Planning Application 24/00539/F

Planning Response Number 2

Having read the planning application for the stadium at the triangle in Kidlington we have the following concerns:

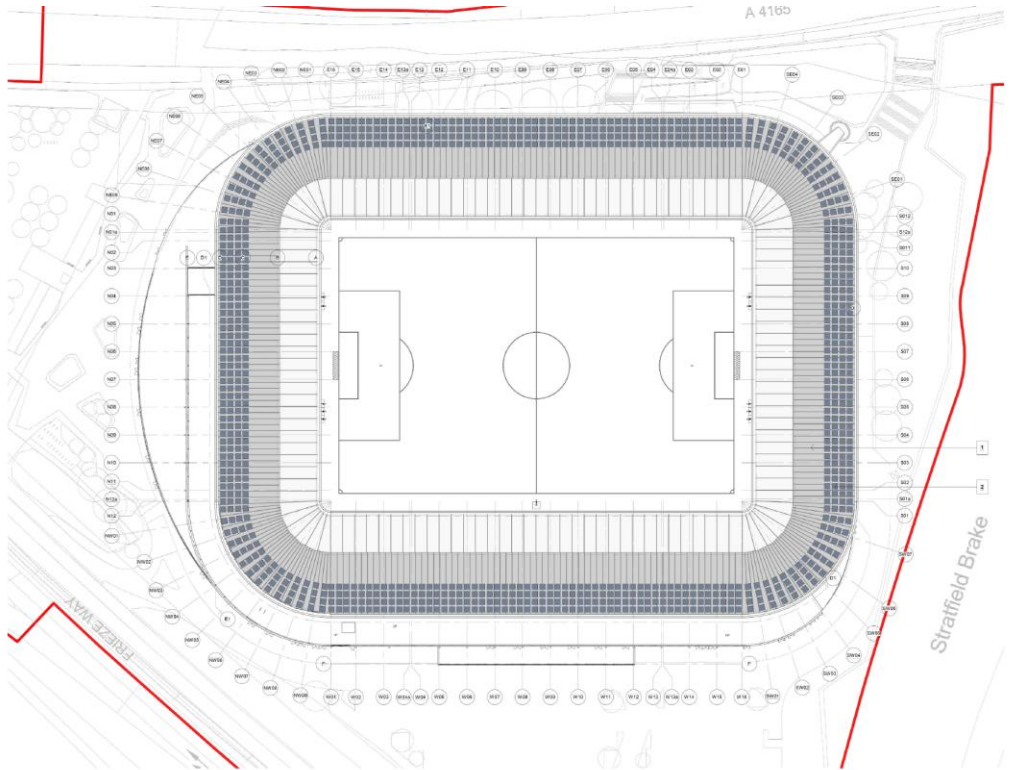
This could not be delivered from a 3,000m² array on site, even if the whole of that array covered the entire area (limiting any suggested green roof potential). This is because solar power does not generate on match nights or effectively during the winter. Simply buying green energy is off-setting and far away from the promises being made here.

Page 113 (24) of the Sustainability Statement suggest that PV generation (table 9) will generate 17.92kWh/m²/year. On 3,000m², that is just 53,760kWh per year.

Effectively equivalent to the consumption of perhaps 13 average UK semi-detached houses. A very small solar array given the size of the claimed available roof space.

What is the actual renewable energy generating install that will be installed on this site and how much electricity will it generate compared to the planned site electrical consumption in kWh?
